Application number: 2023/91316	
What is the application for?:	Demolition of existing garage and erection of single storey side and rear extens
Address of the site or building:	10, Park Close, Shelley, Huddersfield, HD8 8JF
Postcode:	HD8 8JF

Type of comment: An objection	
Do you wish your comments to be published on the website anonymously?	Yes
<p>REF: Planning Application Number 2023/91316 10 Park Close, Shelley, Huddersfield, HD8 8JF With reference to the letter dated 12th May 2023, we would like to raise the following comments and concerns:</p> <ul style="list-style-type: none"><li>• Objection 1 - Invasion of privacy Due to the bungalow being elevated above existing bungalows below, it is a major concern that the proposed, imposing, extension will seriously impede privacy. Currently, this property is set much further back in its plot with a two-meter, opaque fence surrounding the bungalow at the upper level and offering some privacy. According to the plans, the main living rooms are going to be switched more to the rear (overlooking properties below) and the bedrooms relocated to the front of the property (currently, two of the bedrooms are at the rear of this bungalow which is

Client	Mr & Mrs Dolley	Issued From	
Project	2375 : 10 Park Close : Domestic Extension	Date	March 2023
Title	Existing and Proposed Site Plans	Scale	1:100 @ A1
Drawn	BH	Auth	BH

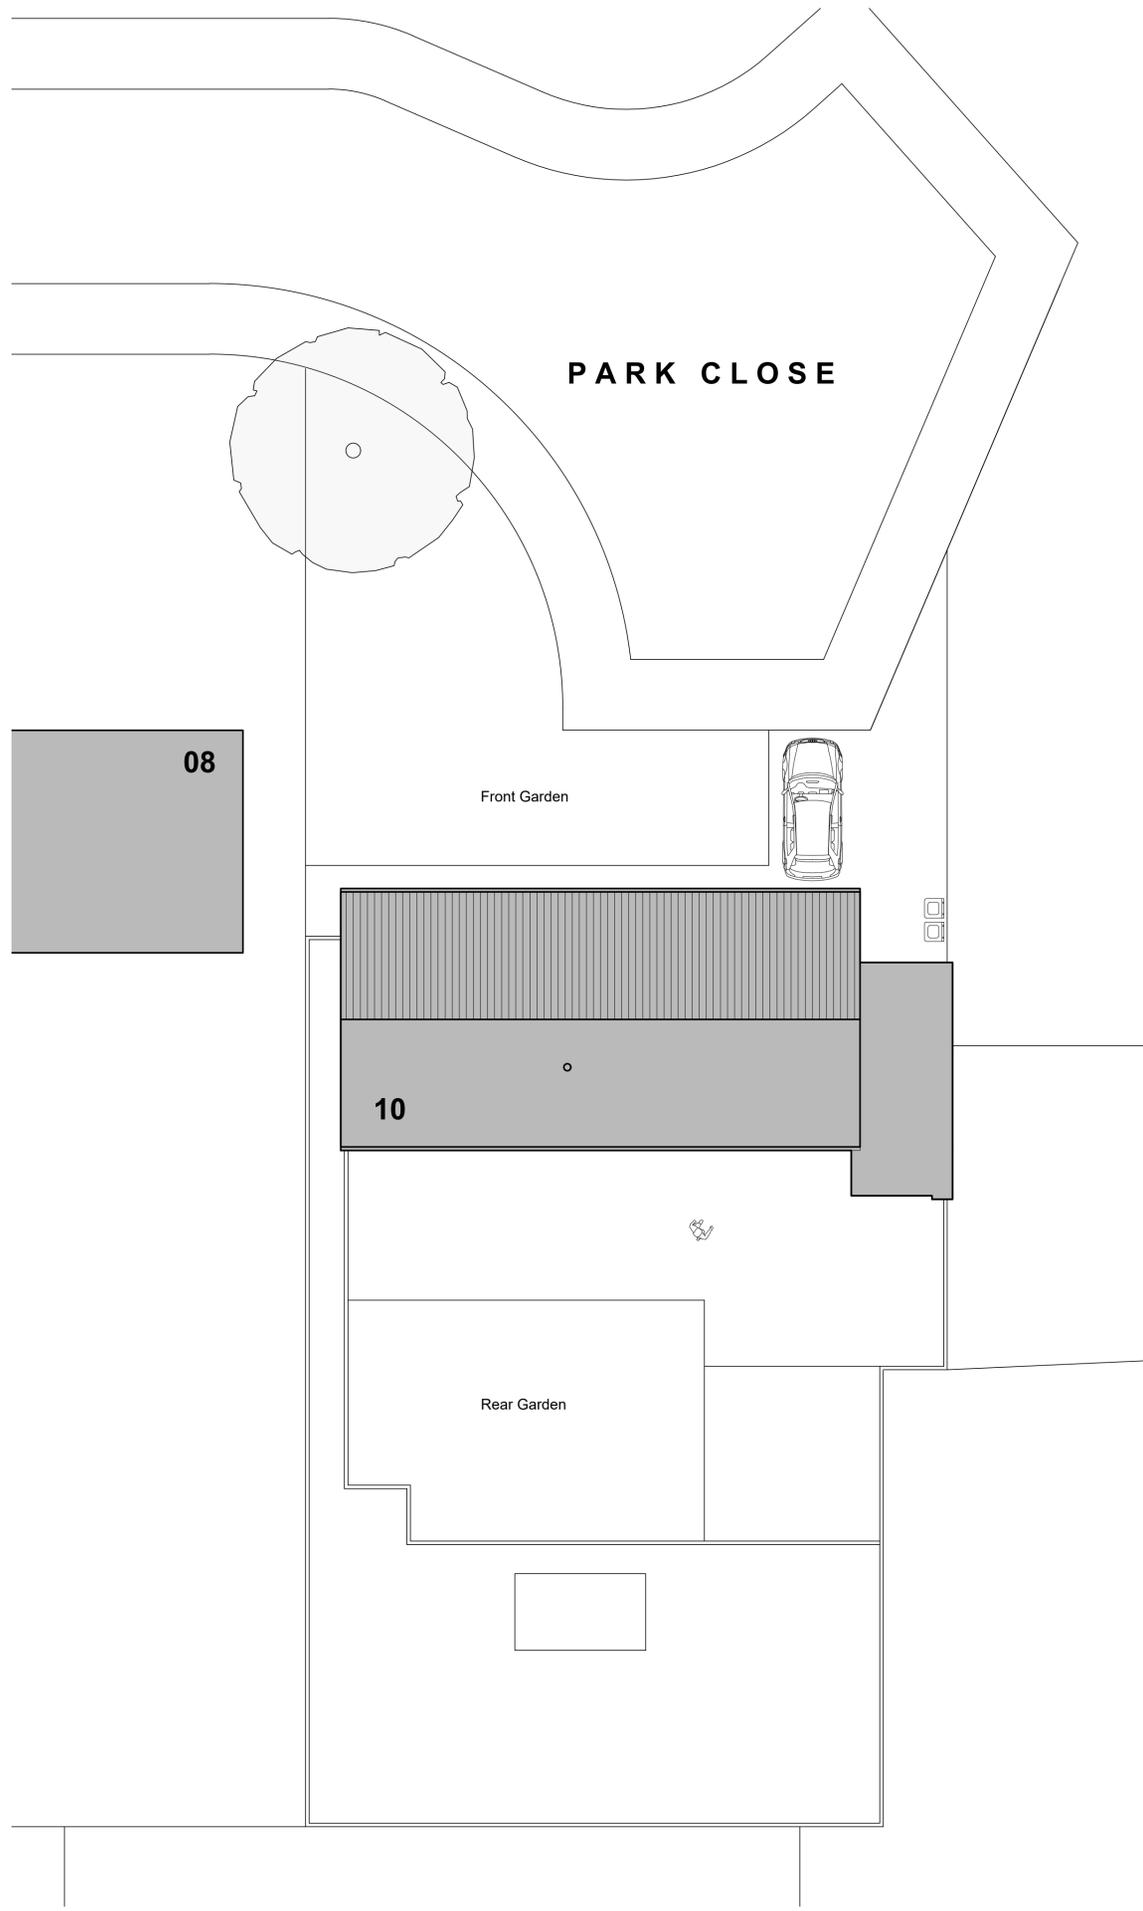
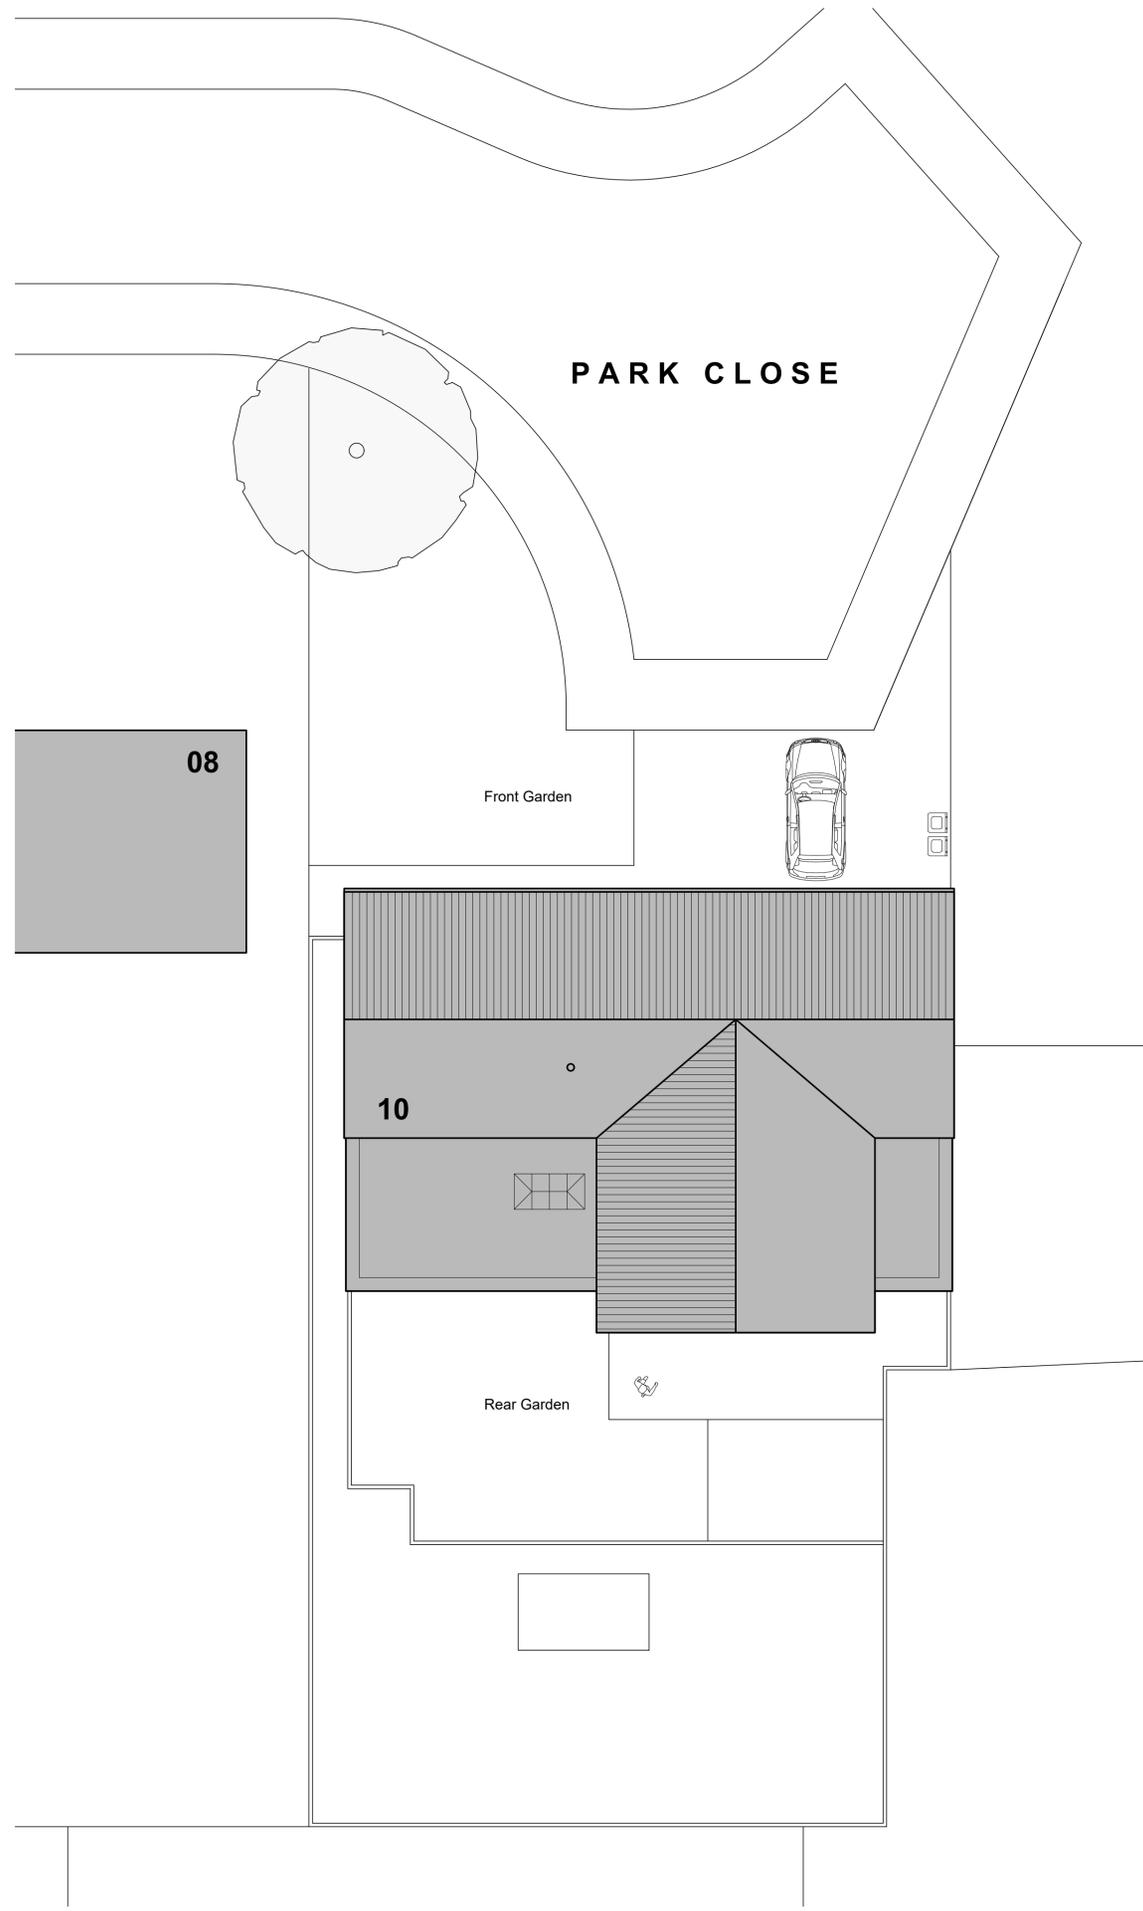
- **Objection 3 - Scale of the extension**

No other bungalow, near this one, has extended to this extent. The extension is almost as large as the original bungalow and detracts from the original character of the site.
